From: Jacob Halverson <jacob.halverson@mercerisland.gov>
Sent: Friday, December 8, 2023 2:30 PM
To: Dave @ Chesmorebuck
Subject: Comment question - #2306-124 5425 W. Mercer Way

Following up with your question regarding the third party reviewer comment. After our conversation I believe we are discussing the area located here in the project.

MAIN FLOOR

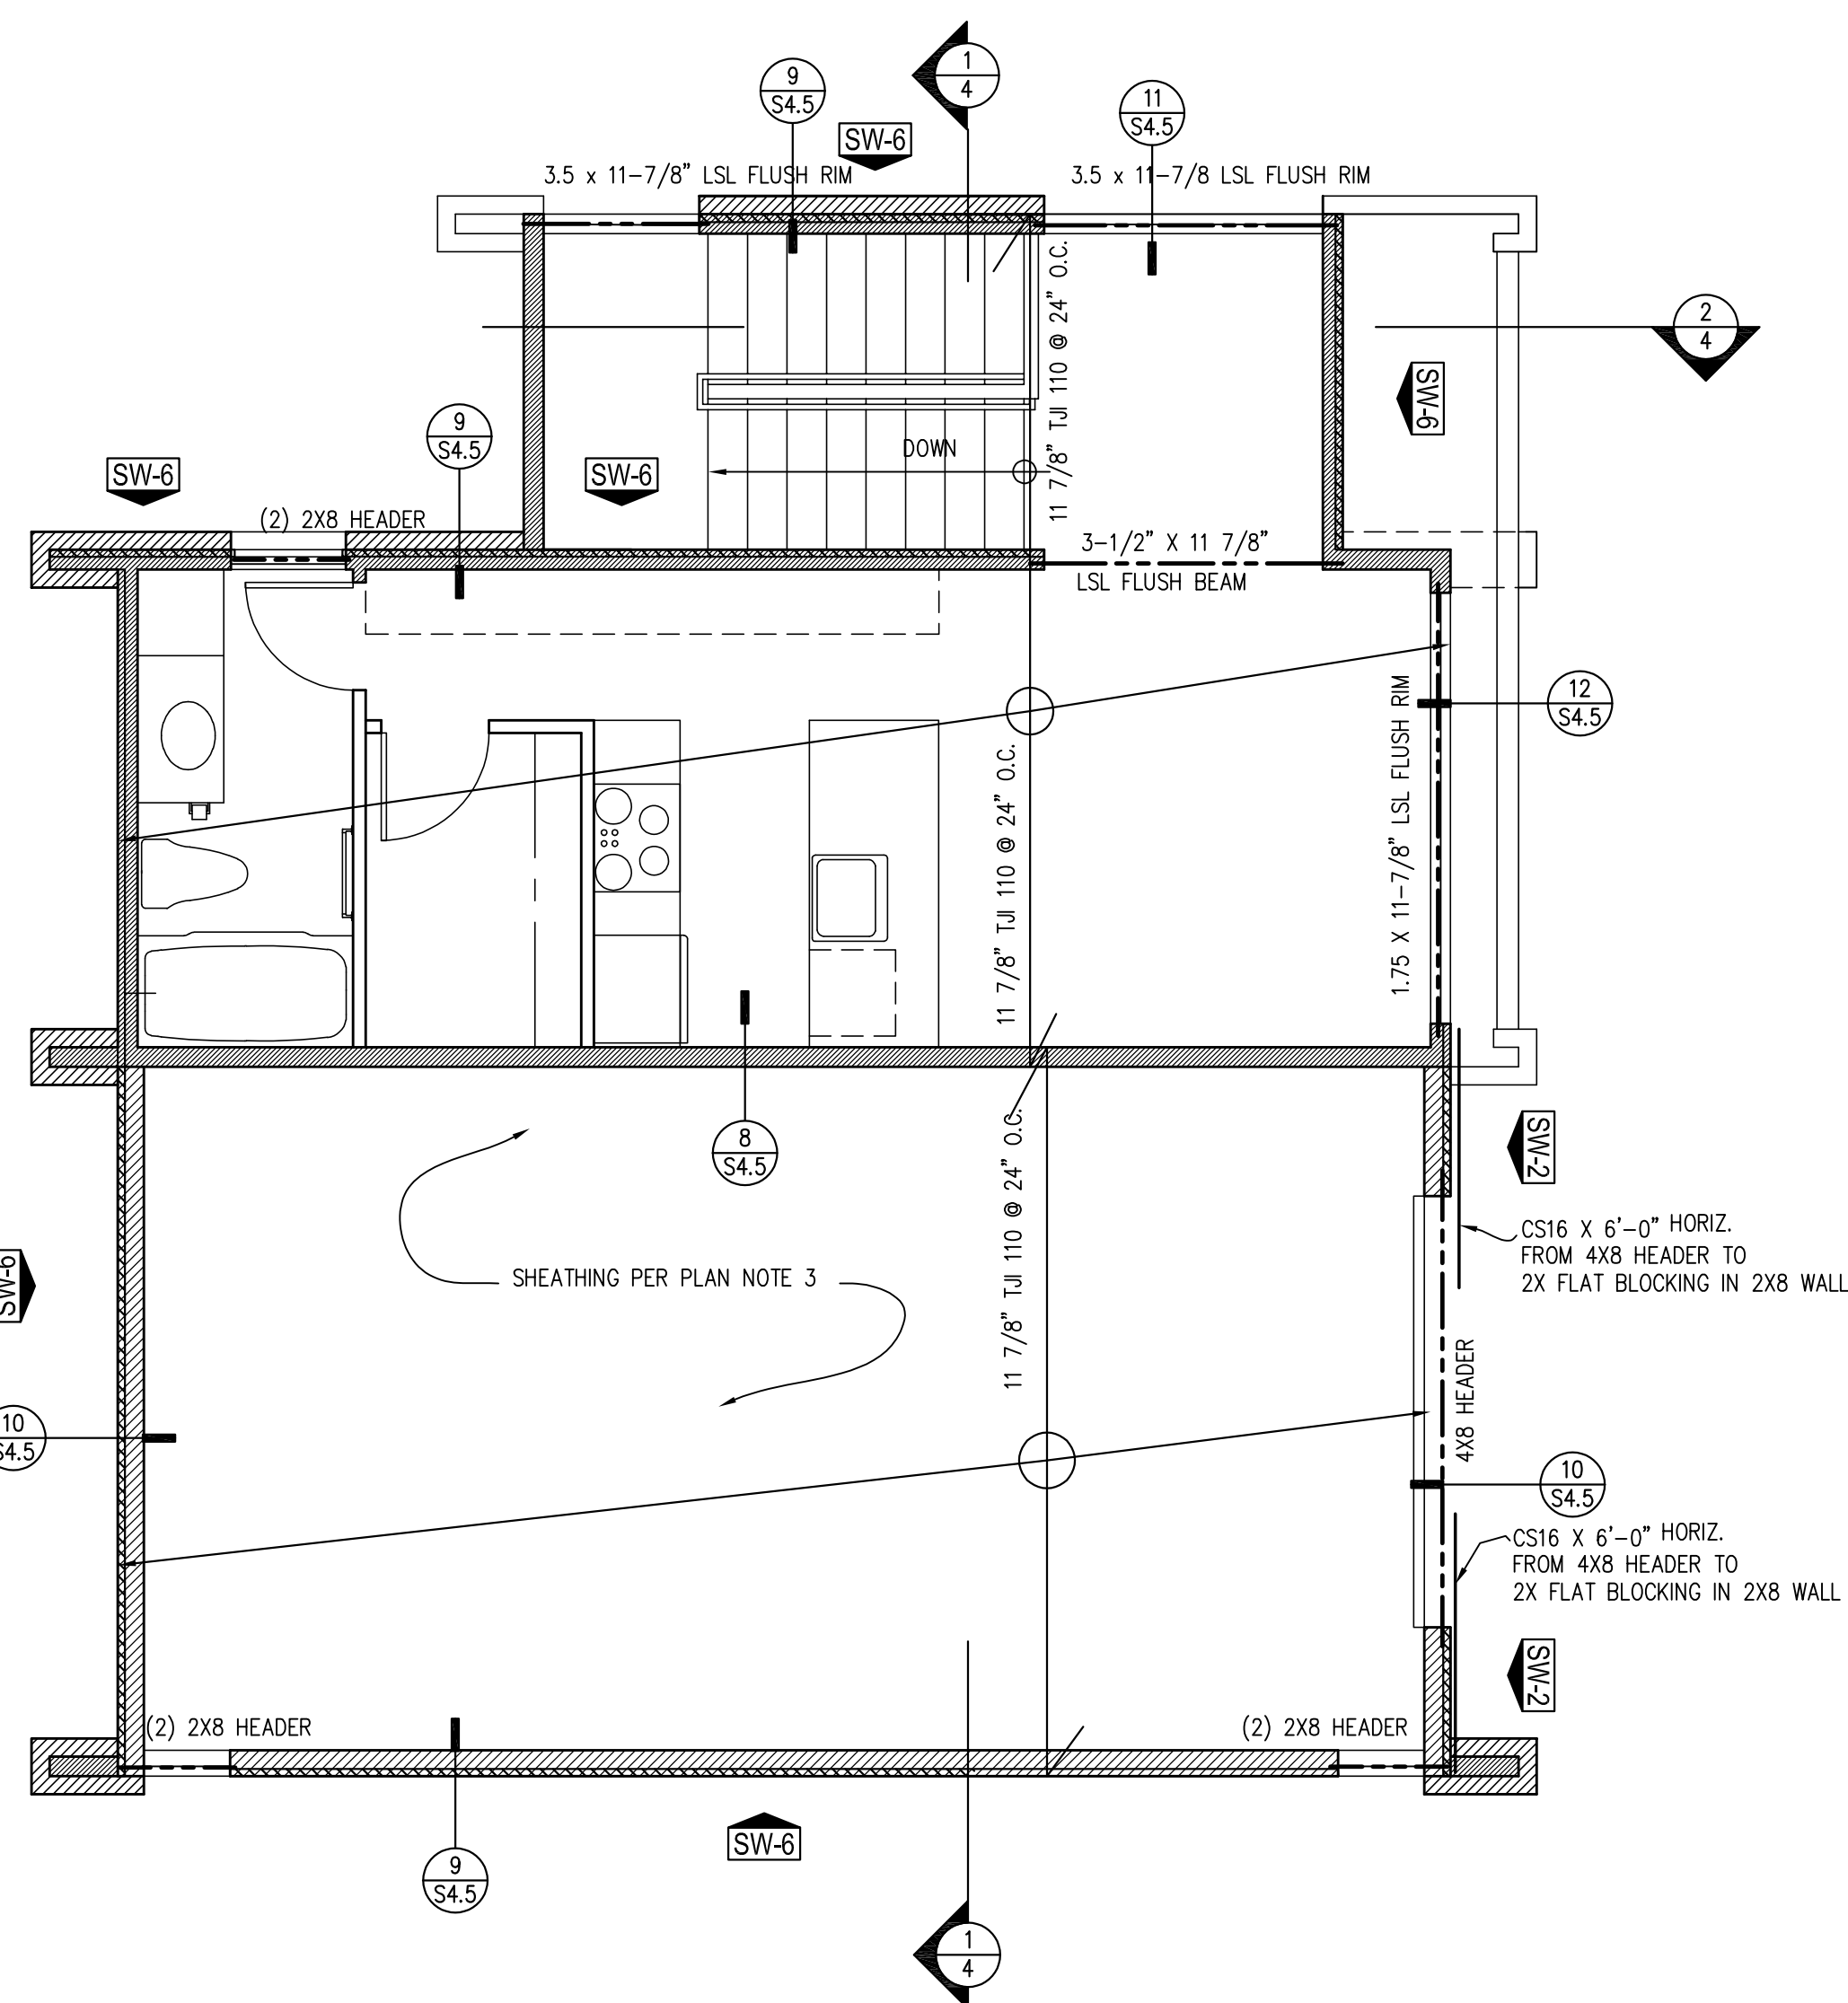
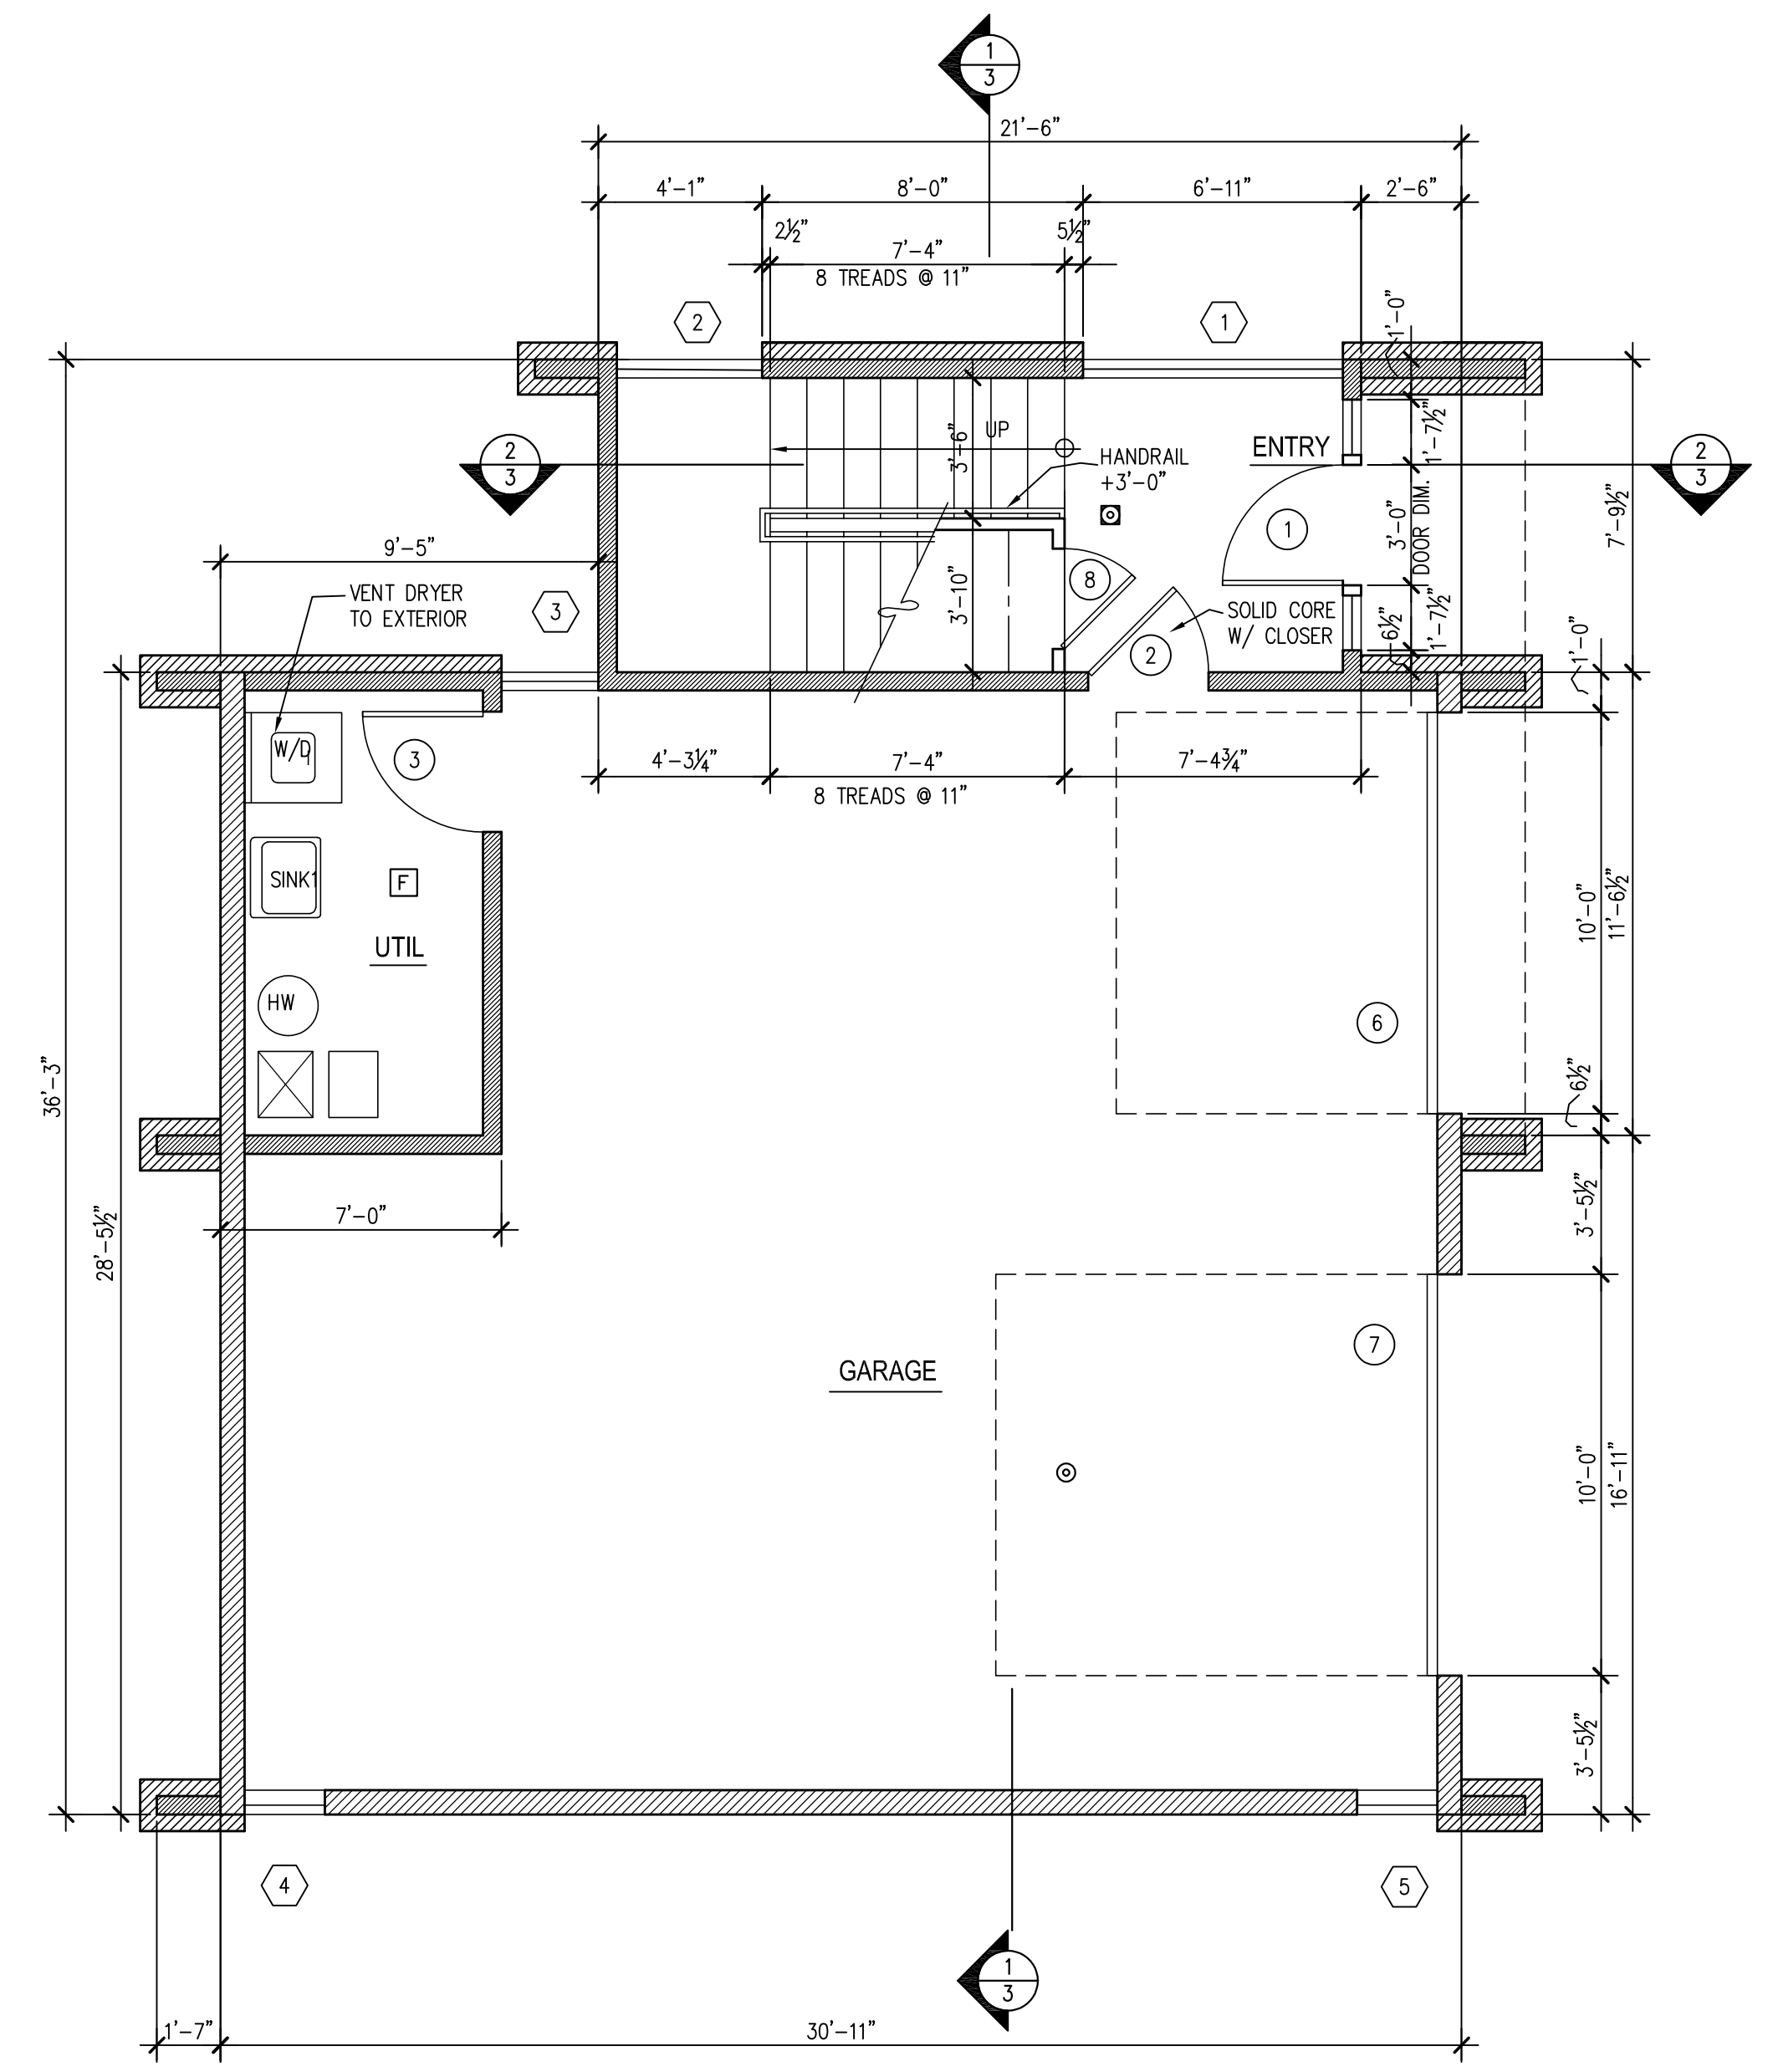
1. Openings from a private garage directly into a room used for sleeping purposes shall not be permitted per IRC R302.5.1. Please provide an additional door to the sleeping area at the DADU. A condition without this additional door would need to be approved by the building official.

I understand your interpretation as the professional is that the door does not lead directly into the sleeping room. I also see that the layout of this ADU is unique and its relation to the garage would be a cause for concern.

I agree with your interpretation that this door does not lead directly into the living area. With the key word being directly. I understood that you are revising the upper floor to provide an additional means of egress out of the "living" room in response to another comment via an emergency escape and rescue opening requirement. If this is the case it also eases any concern I have for this condition.
